Harnett County Government Complex  
307 W. Cornelius Harnett Boulevard  
Lillington, NC 27546

March 20, 2009

**Re: Status of Improvement Permit Application Lots 3 & 4 Bill Avery Road #09-5-21723 & #09-5-21710R**

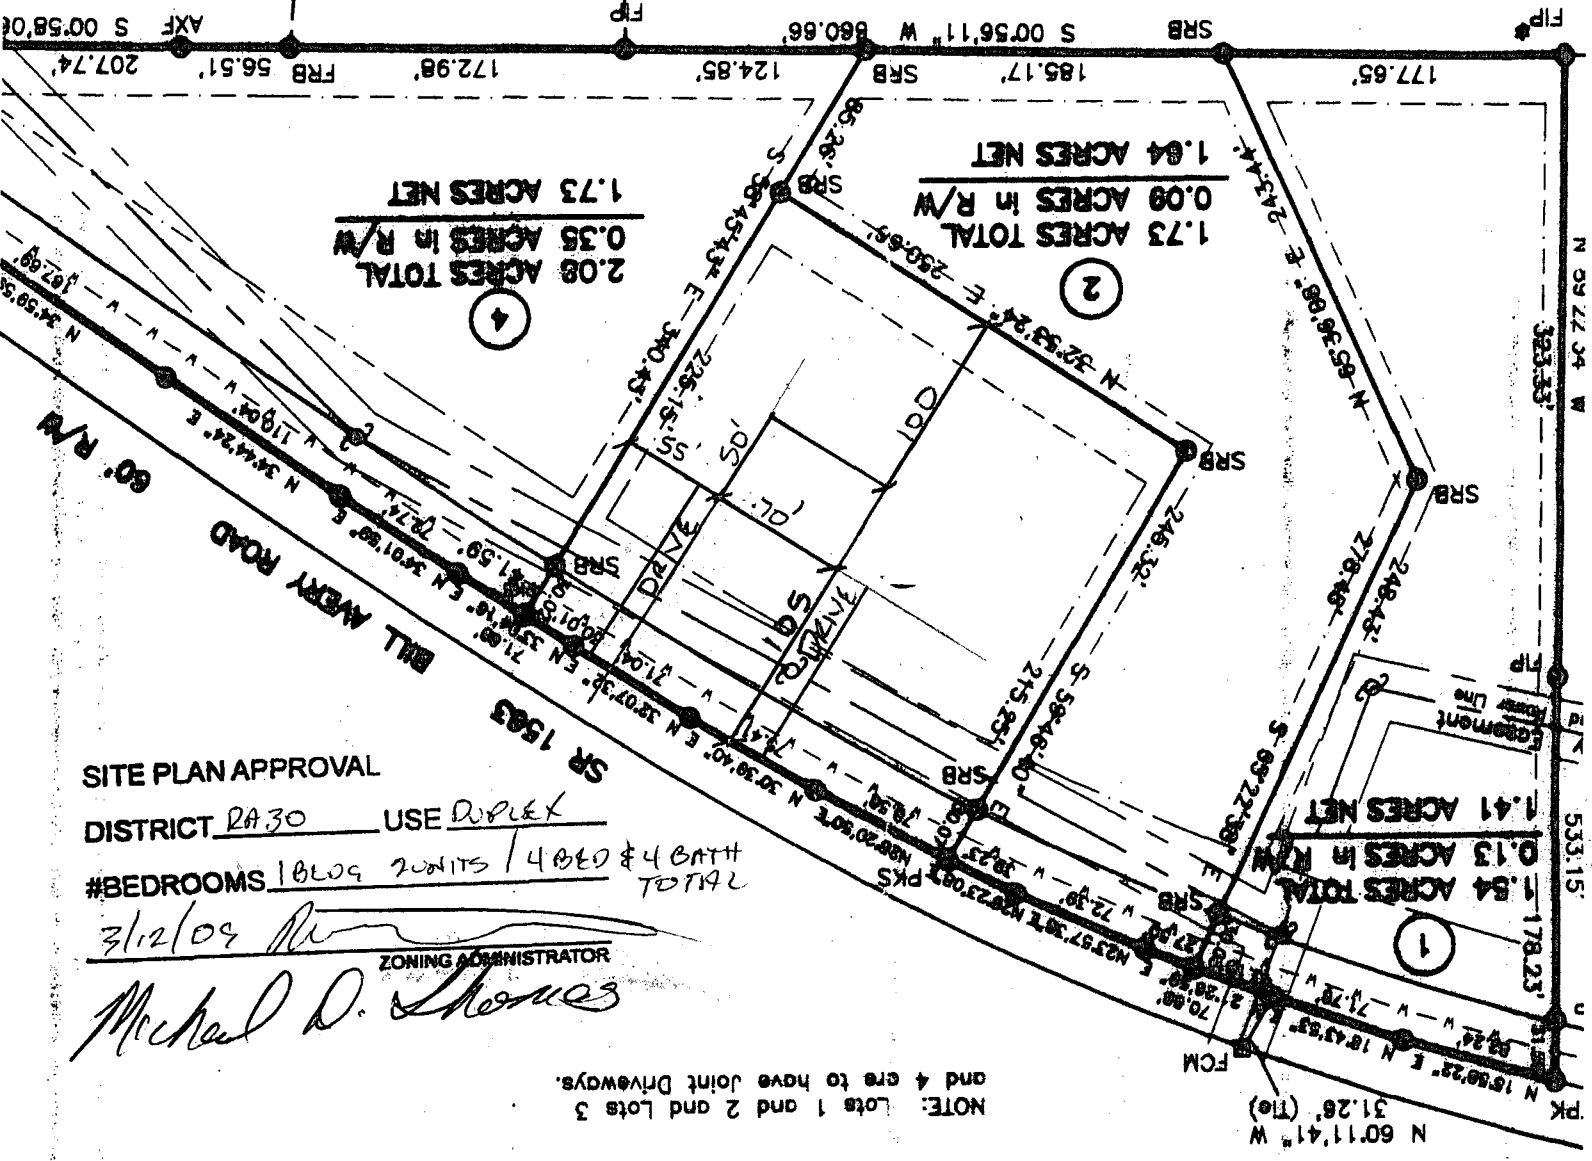
- 1. Property lines/corners not marked or labeled *(\$25.00 fee incurred)*
- 2. House corners not marked or labeled *(\$25.00 fee incurred)*
- 3. Directions not clear to property *(\$25.00 fee incurred)*
- 4. Property needs brush or vegetation removed
- 5. Backhoe pits required
- 6. Other – Setbacks are incorrect on both lots.
